An
Coimisiún
Pleanála

R318314_TN

Development 500 seat outdoor community amphitheatre.
Former Council Depot at Commons North Lime
Quarry, Lanesborough, Co. Longford.

Topic **Ecology Technical Report.:** Adequateness of
scientific information for Biodiversity/Appropriate
Assessment

Figure 4: Revised Proposed Landscape Plan

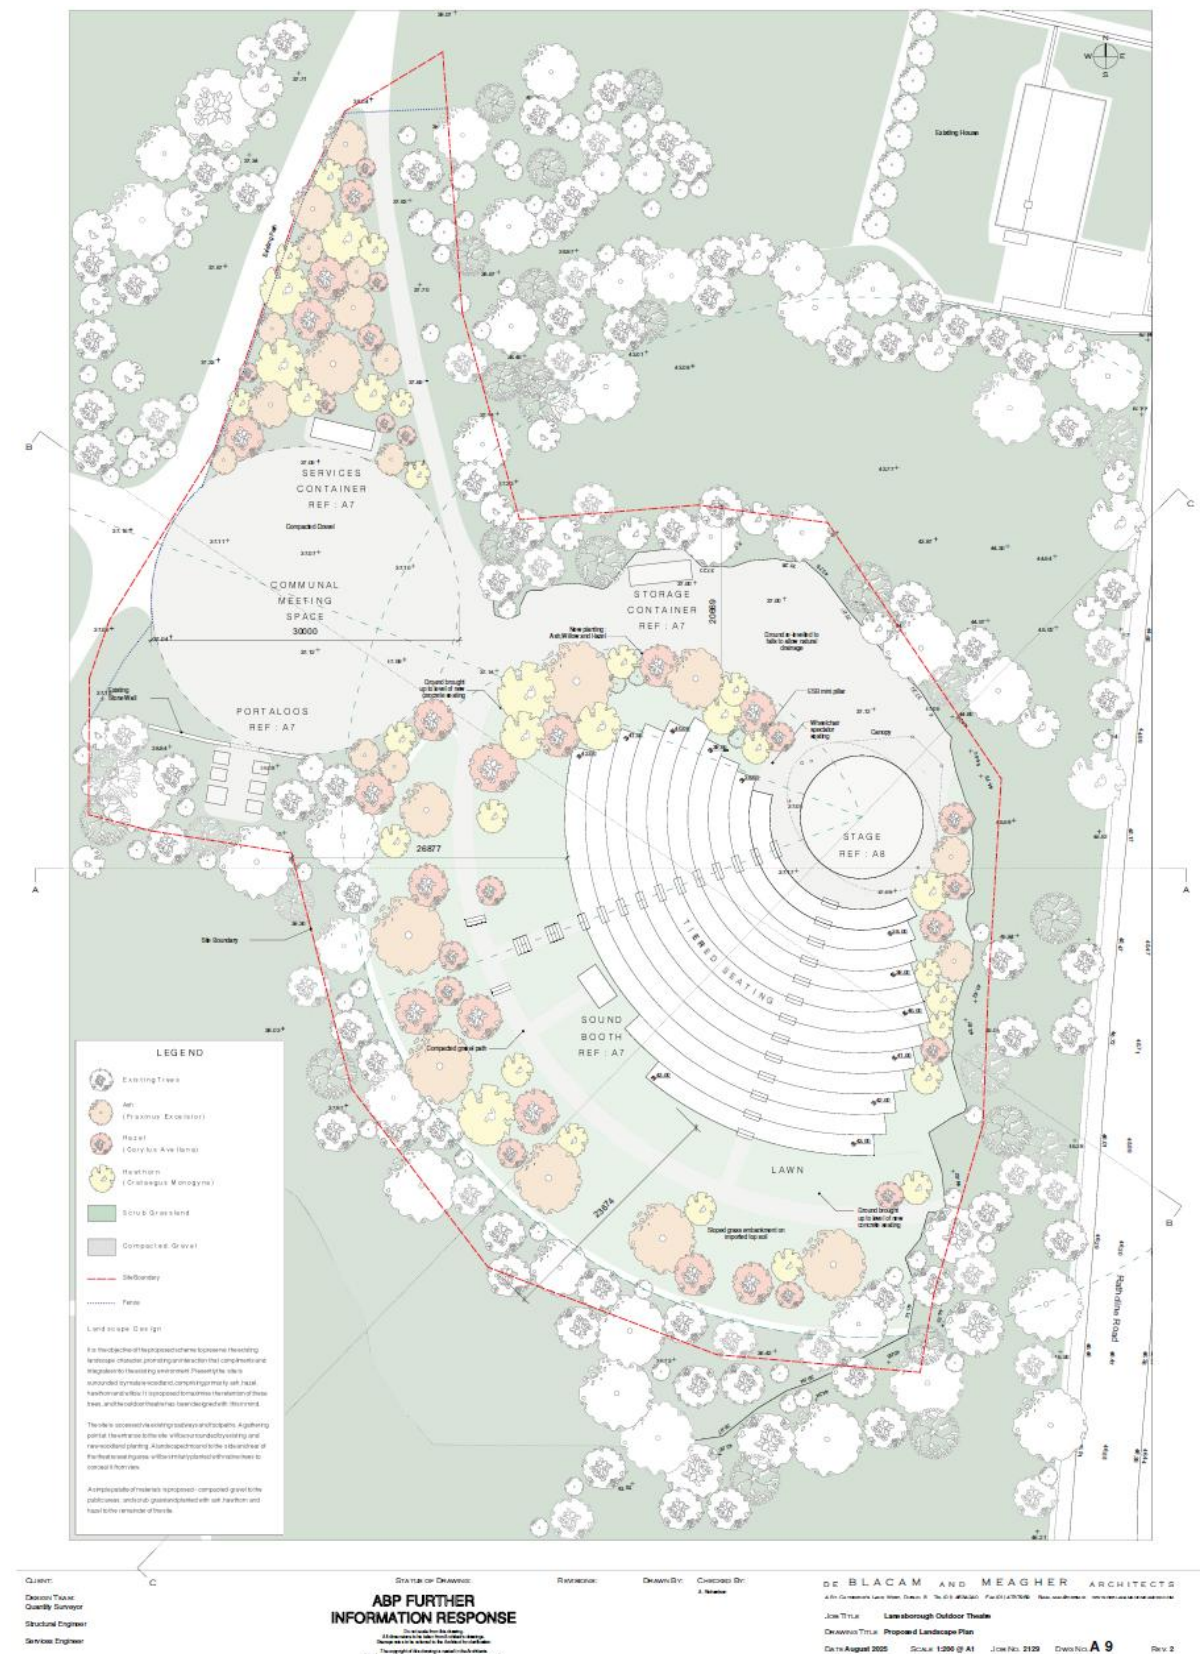
- 3.1. With reference to Item 5 in the DAU submission to the original application “*Areas of habitat removal have not been identified*” I feel that this item has not been adequately assessed in the further information response documentation. The areas of habitat loss, particularly within the boundary of Lough Ree SAC have not been presented. It is noted that the habitats within the development site, for the most part, are disturbed and reflect the previous quarry and current council compound activities. My main concern however is the woodland habitat bordering the compound area to the south which is within the boundary of Lough Ree SAC and is proposed location for the temporary storage of Portaloos, as indicated in the Proposed Landscape Plan drawing DWG No. A9, see below, area of interest indicated in red circle.

As the woodland is not a QI of Lough Ree SAC it is not assessed under the statutory Appropriate Assessment. Where its significance lies is that it is an Annex I habitat and valuable habitat for local wildlife. Removal of this habitat for temporary storage of portalooos seems like unnecessary loss of semi-natural habitat when there are areas of disturbed ground, hard standing and improved grassland within the development boundary that could amply accommodate such facilities. I recommend that this area is excluded from the grant of permission, if you are minded to do so, and other areas of hardstanding available within the development site are identified for temporary Portaloo storage.

- 3.17. Due to the proximity to designated European Sites, the landscaping plan must prioritise the protection and enhancement of biodiversity using native species of Irish provenance.

- 3.18. The species list for the proposed scrub grassland is not provided; however it must include 100% native species of Irish provenance suitable for the local soil conditions.

- 3.19. The species mix for the lawn grassland is also not provided; however it must include 100% native species of Irish provenance suitable for the local soil conditions

- 3.20. Due to the proximity of sensitive ecosystems, vulnerable to water pollution, there will be no application of fertilizer or other chemicals into grasslands and landscaped areas within the site. If possible, source grass seed from green hay sourced from a local area of species rich grassland can be scattered in the target areas. In new areas identified for species diverse grassland, topsoil from excavations within the site during construction will be put aside and spread on these areas, to ensure a seed bank of local provenance is in place to allow this habitat to establish.

Figure 5.1 Protective measures for amphibian breeding habitat¹¹

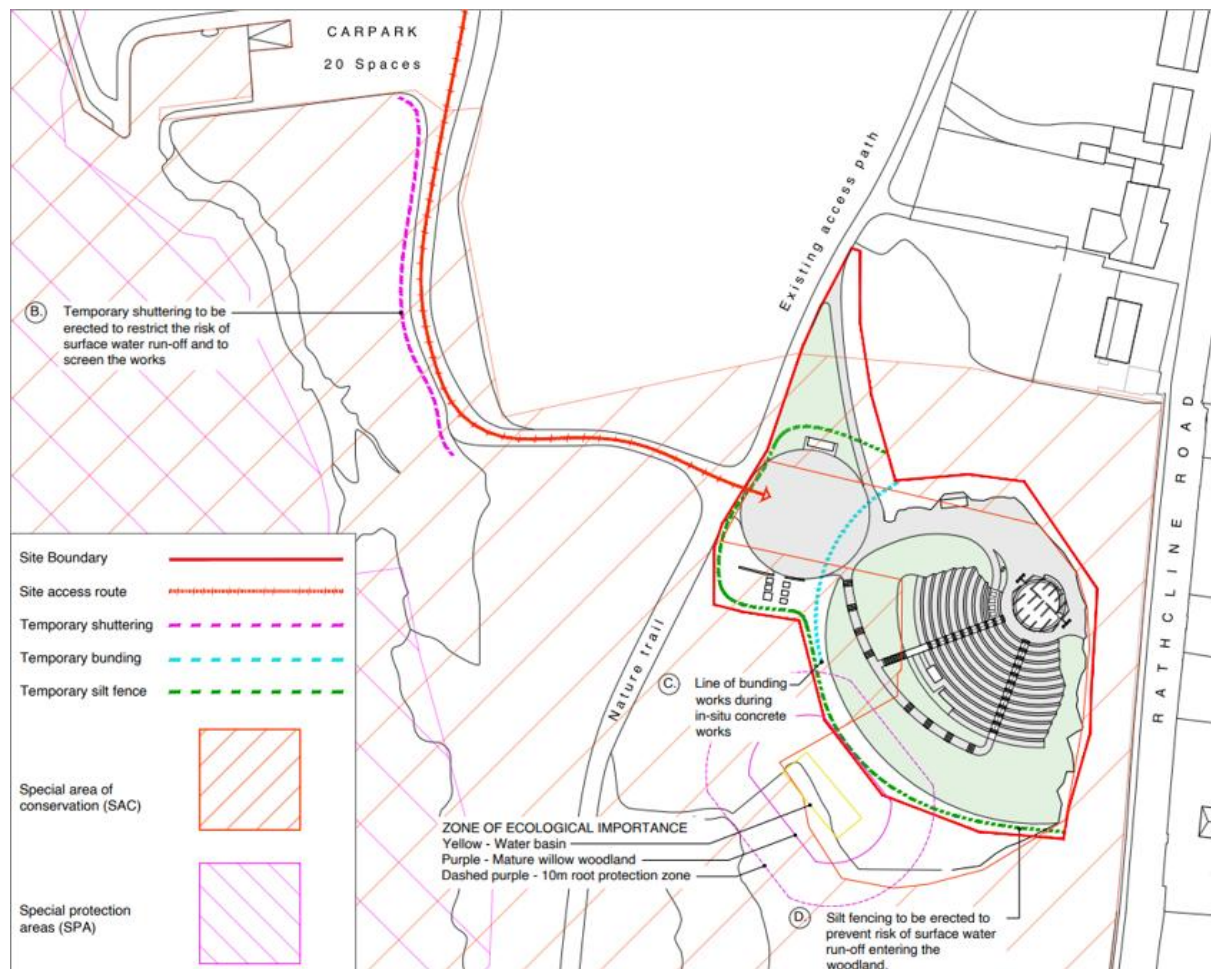
- 3.12. Amphibian surveys carried out during in the breeding season at the ephemeral pond within the proposed development site found no evidence of breeding frogs or newts, however it is noted in the report that this could be attributed to recent disturbance at the pond from activities at the compound. The report highlights that there is also an inaccessible pond within the woodland to the south that would provide suitable habitat for the species, the location is shown in Figure 5.1 and within the “Zone of ecological importance”.

- 3.13. Through the implementation of mitigation measures set out in the Report on Supporting Ecological Surveys Section 5.2, the Hydrological Investigation Mitigation Measures Section V and A10 Outline Construction Management drawing, specifically the Zone of Ecological Importance, and protection of amenity grasslands during events, impacts to amphibians can be minimised.
